DRB CASE ACTION LOG (FINAL PLAT)

DRB Application No.: **05DRB-00210 (FP)**
Project Name: **No Albuquerque Acres Unit 3**
Agent: **Surveys Southwest Ltd.**

DRB CASE NO/PROJECT NO: 1003761

RE: Lots 14, 15 & 16, Block 20, Tract 3, NAA/minor plat

PLAT OF
LOTS 14-A & 15-A, BLOCK 20, TRACT 3, UNIT 3
NORTH ALBUQUERQUE ACRES
SITUATE WITHIN PROJECTED SECTION 17,
T. 11 N., R. 4 E., N.M.P.M.
ELENA GALLEGOS GRANT
CITY OF ALBUQUERQUE
BERNALILLO COUNTY, NEW MEXICO
APRIL 2005
PAGE 2 OF 2

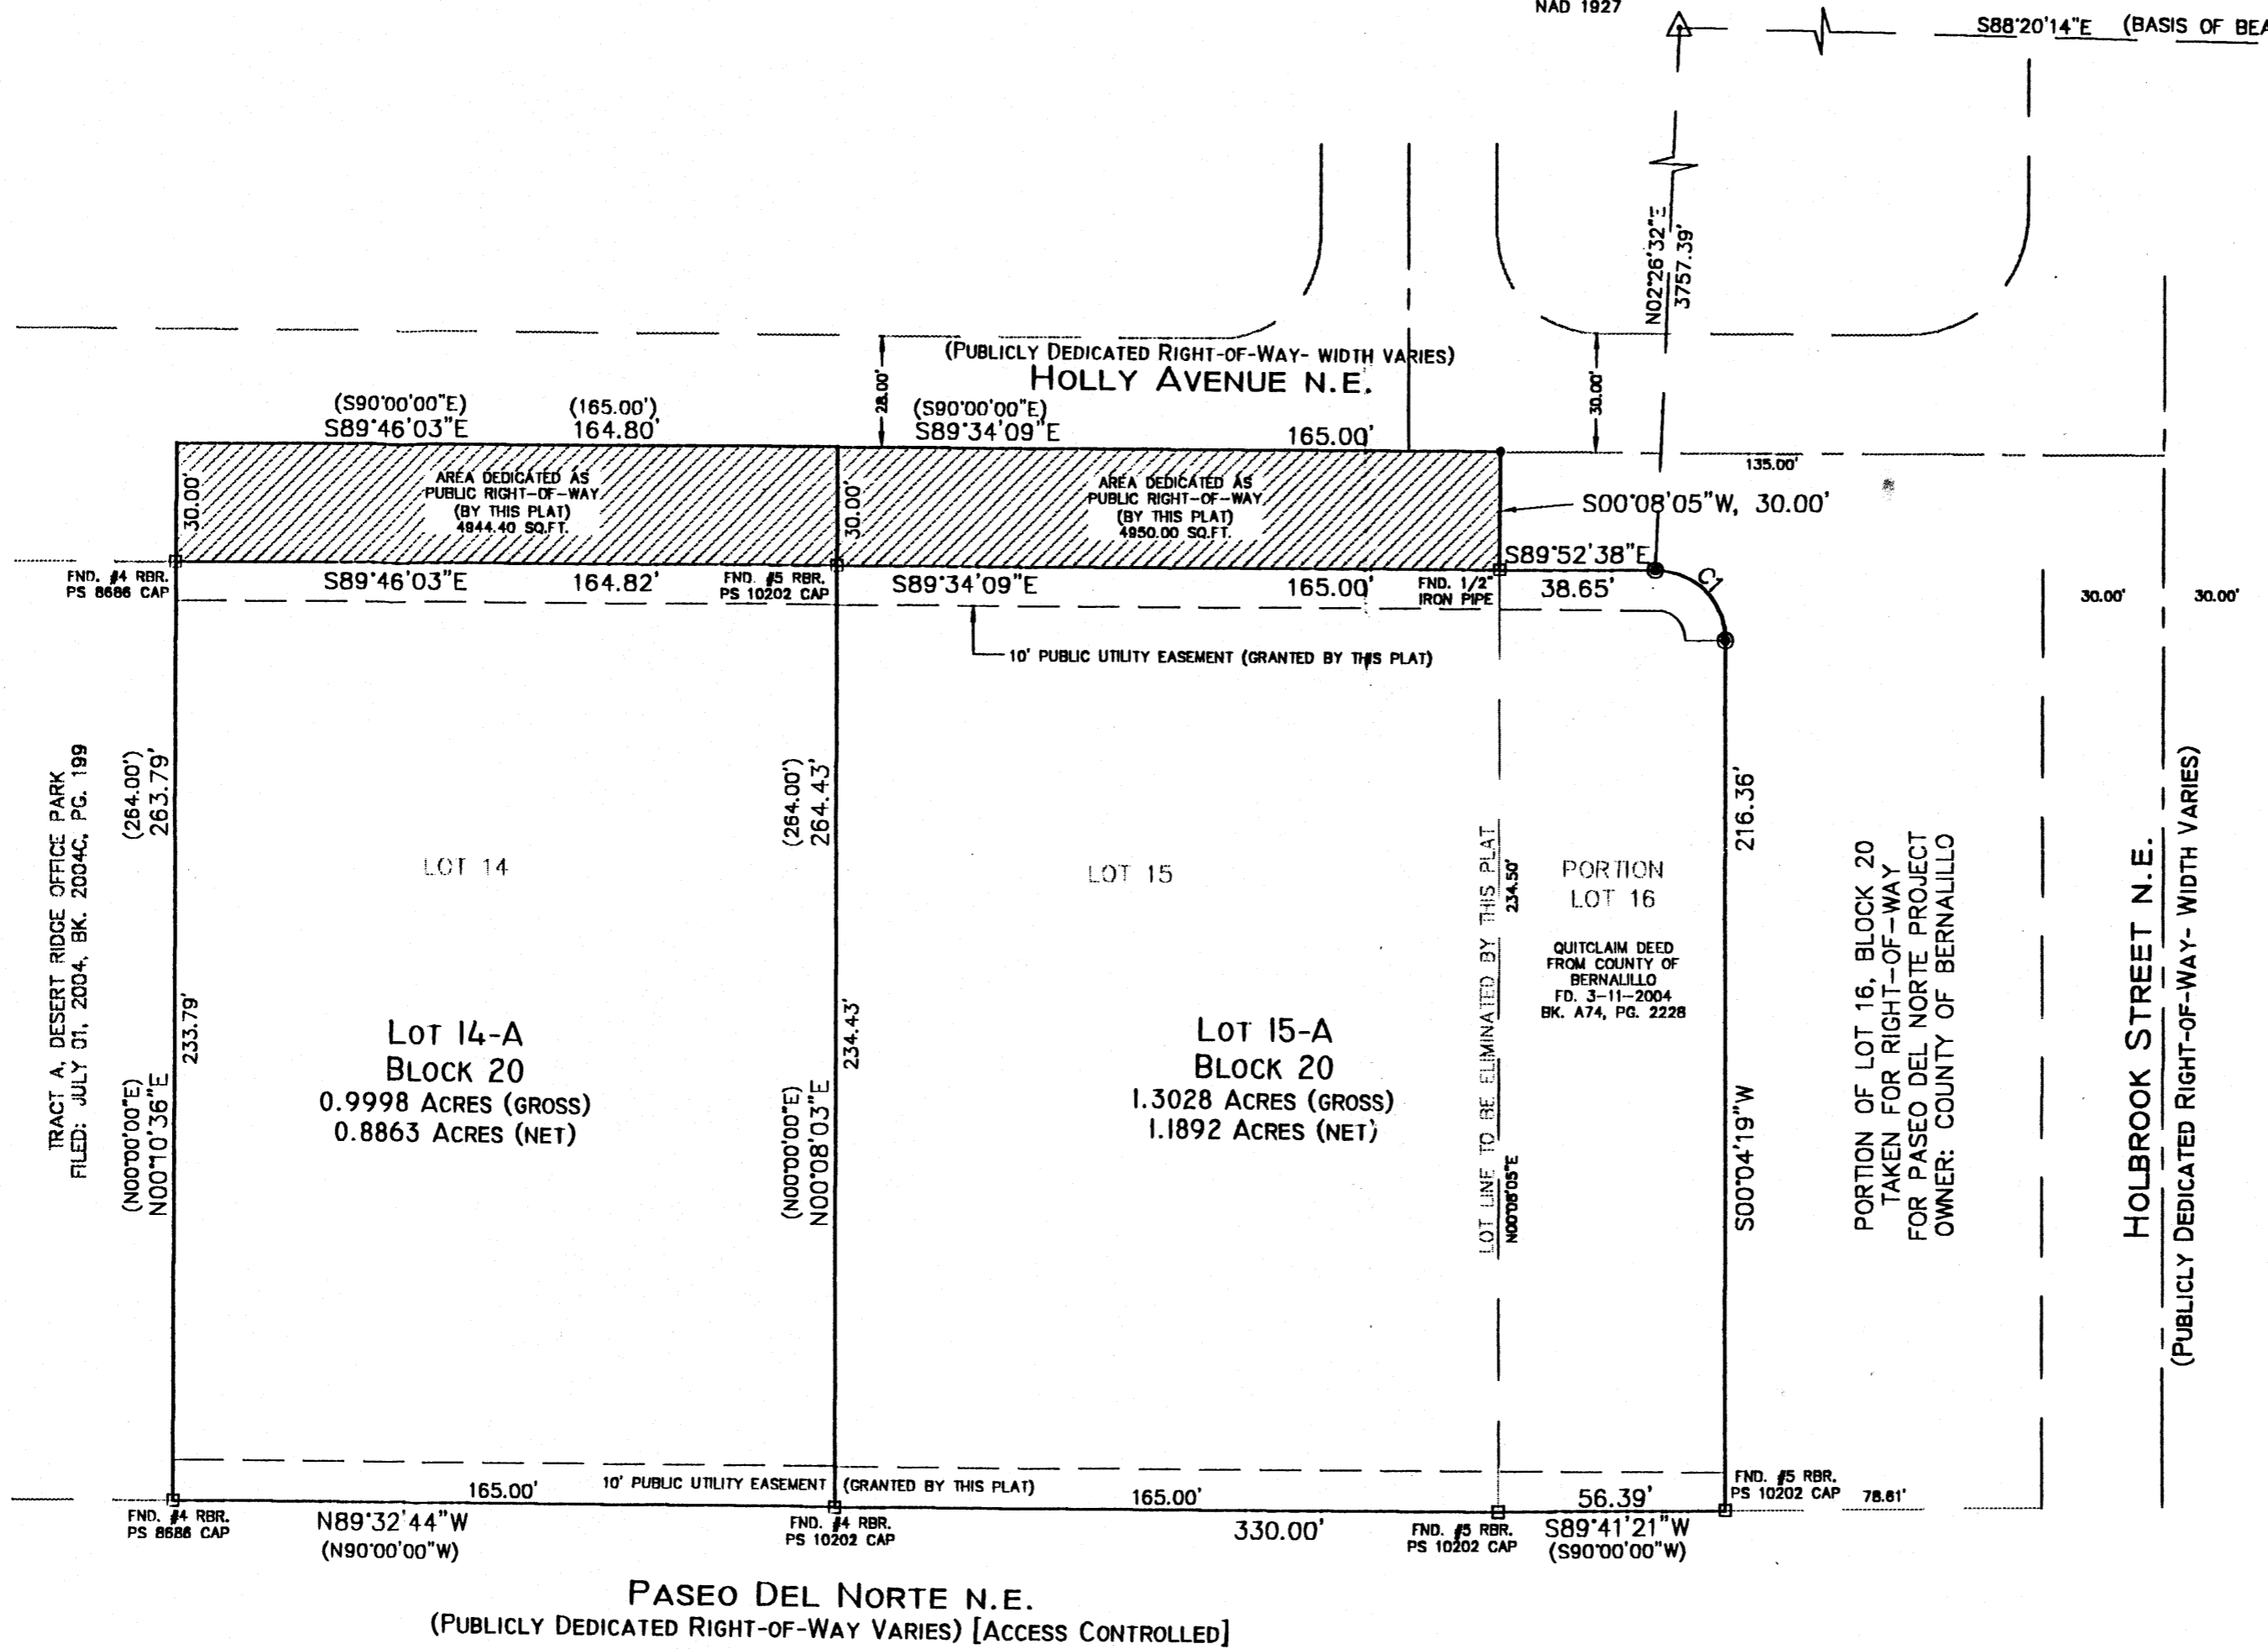
Need cross-lot drainage easement.
